Ref: D2016/30968

Section 96(2) Modification Application to Warehouse and Distribution Facilities at Oakdale Central (Lots 1C, 2B & 3) (SSD 6078 MOD 5)

Thank you for your letter of 21 March 2016 inviting comment on the above s96 modification application in Oakdale Central that seeks to convert an approved single warehouse facility into four separate warehouse facilities and extend the estate road from Millner Avenue.

EXISTING RETAINING WALL TO BE ADJUSTED
EXTENT TO BE CONFIRMED

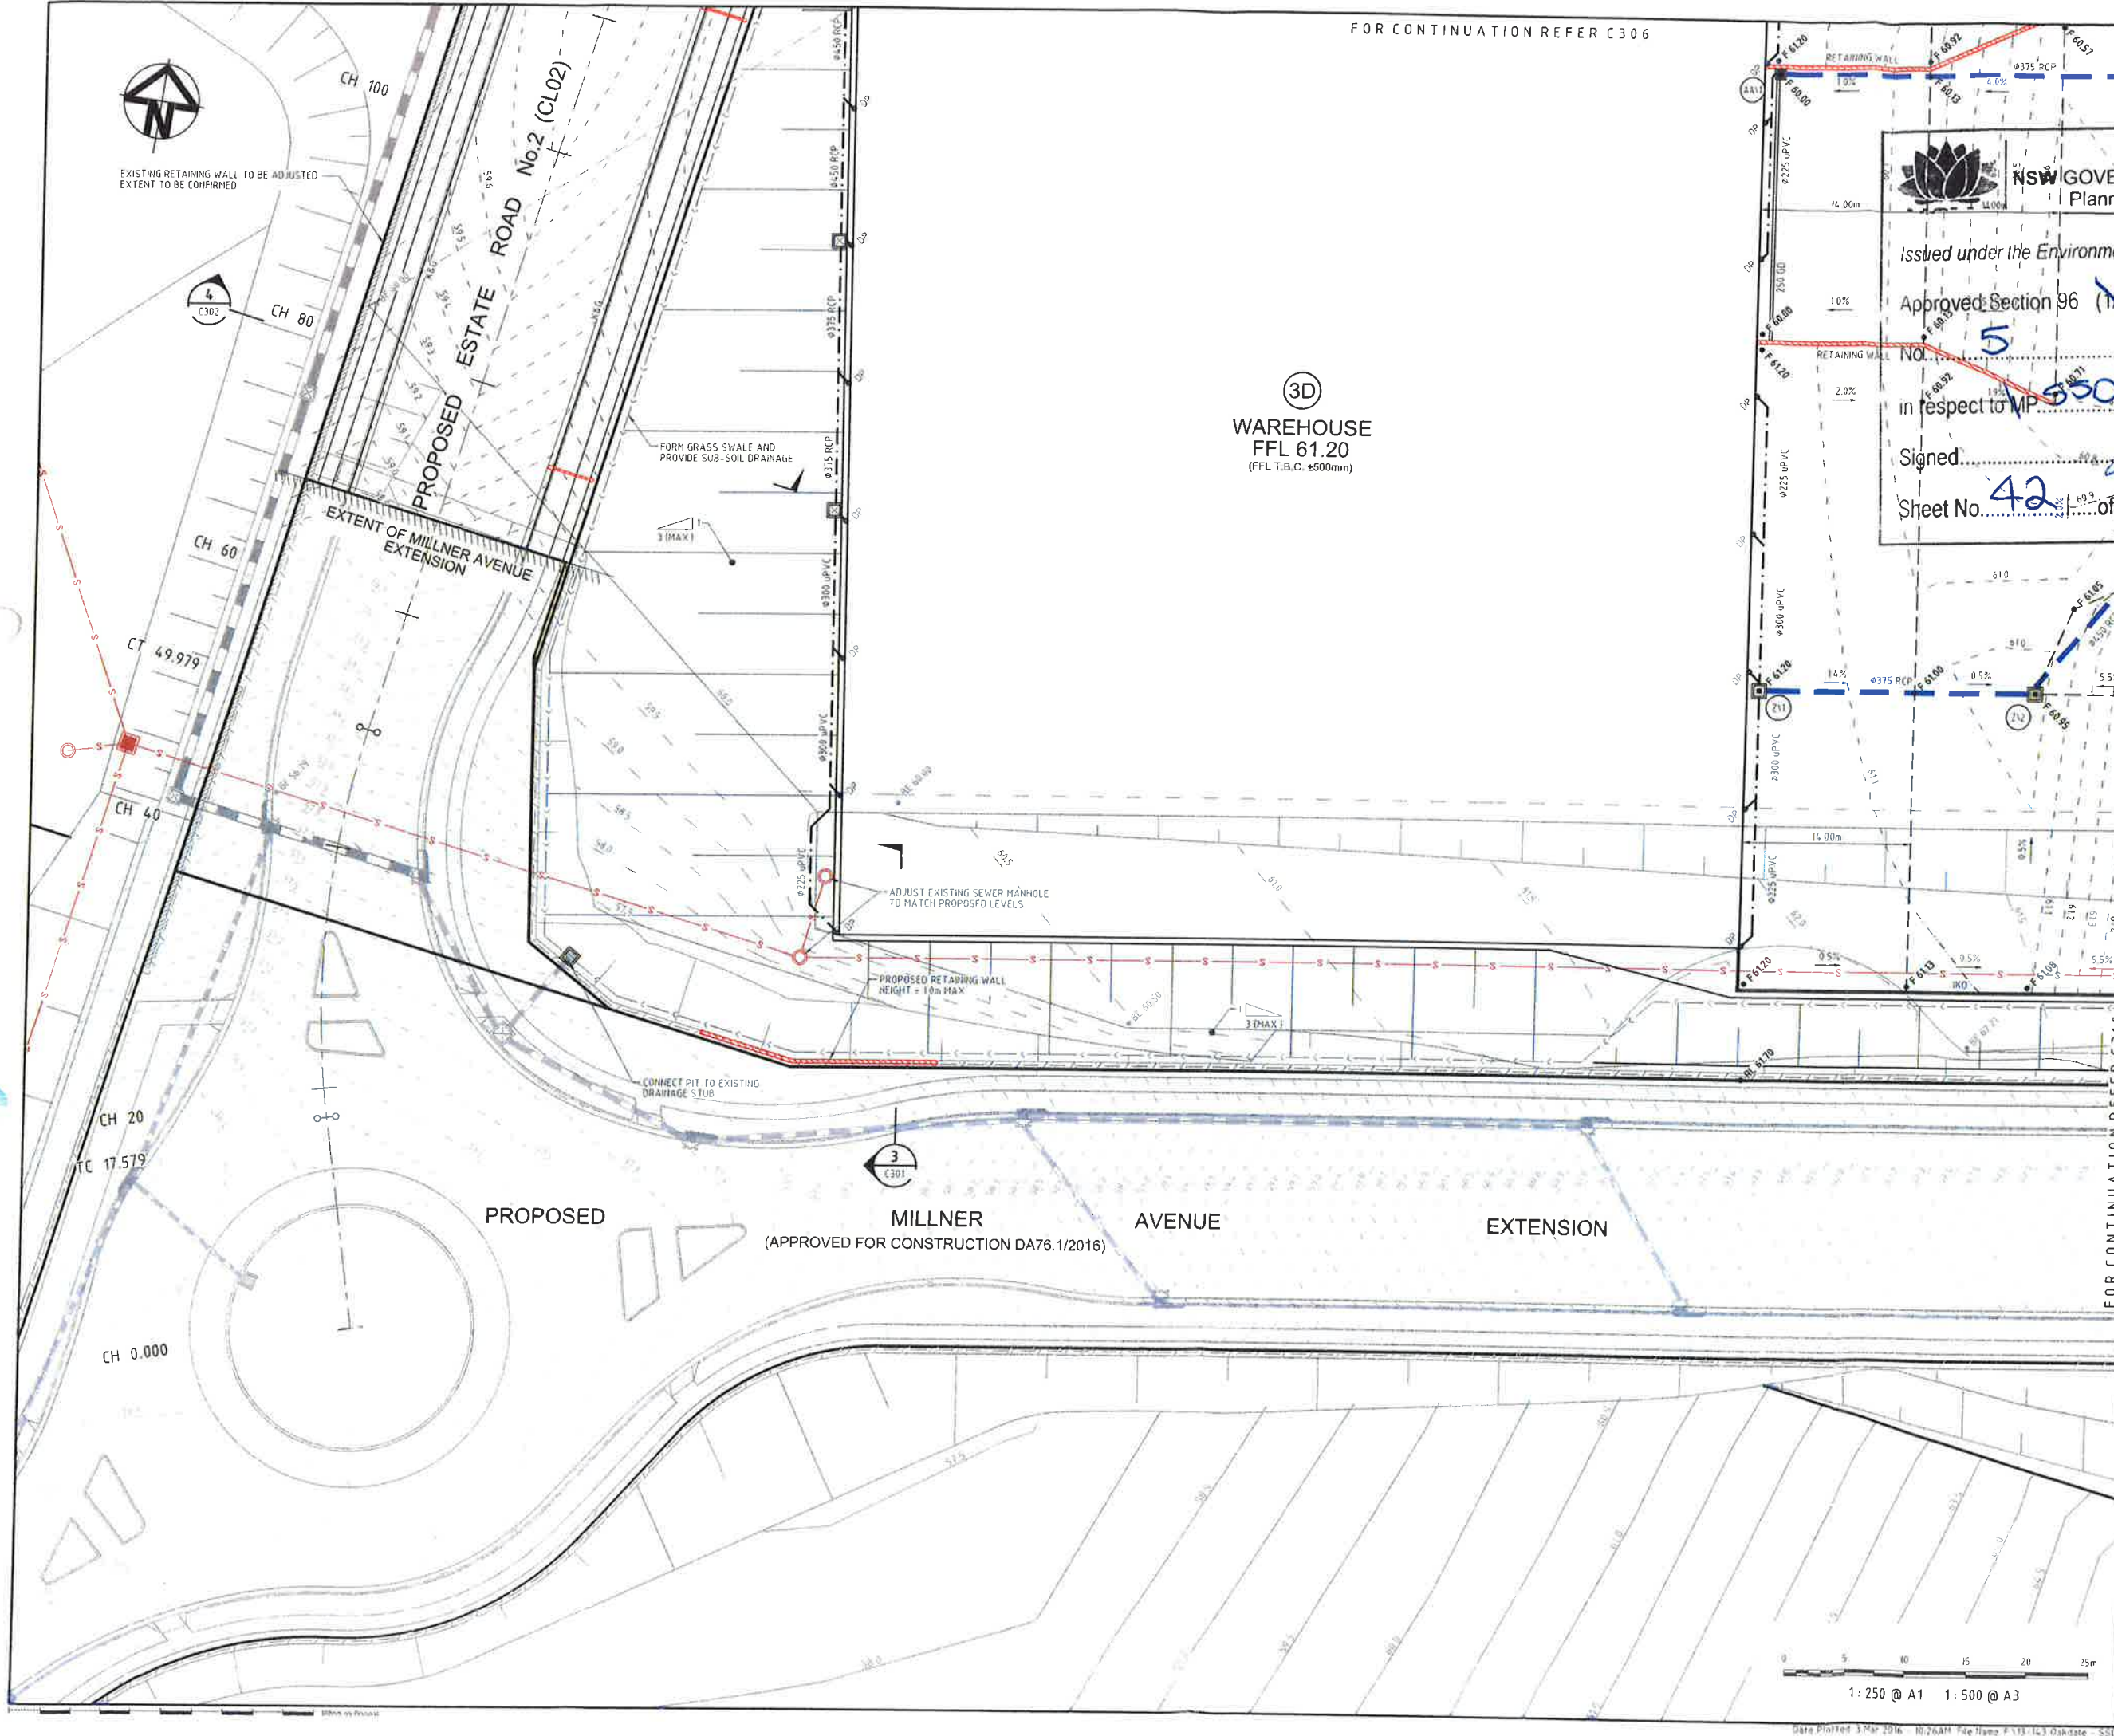
It is noted that the proposed modification is entirely located within the existing land lot, however the northern retaining wall is proposed to be adjusted higher by an additional 800mm, and a new car parking area established between proposed warehouse 2A and the pipeline corridor boundary. WaterNSW requests that all relevant conditions, including those relating to the installation of appropriate traffic barriers and security fencing to the satisfaction of WaterNSW, as well as incident notification are carried over should the modification receive approval.
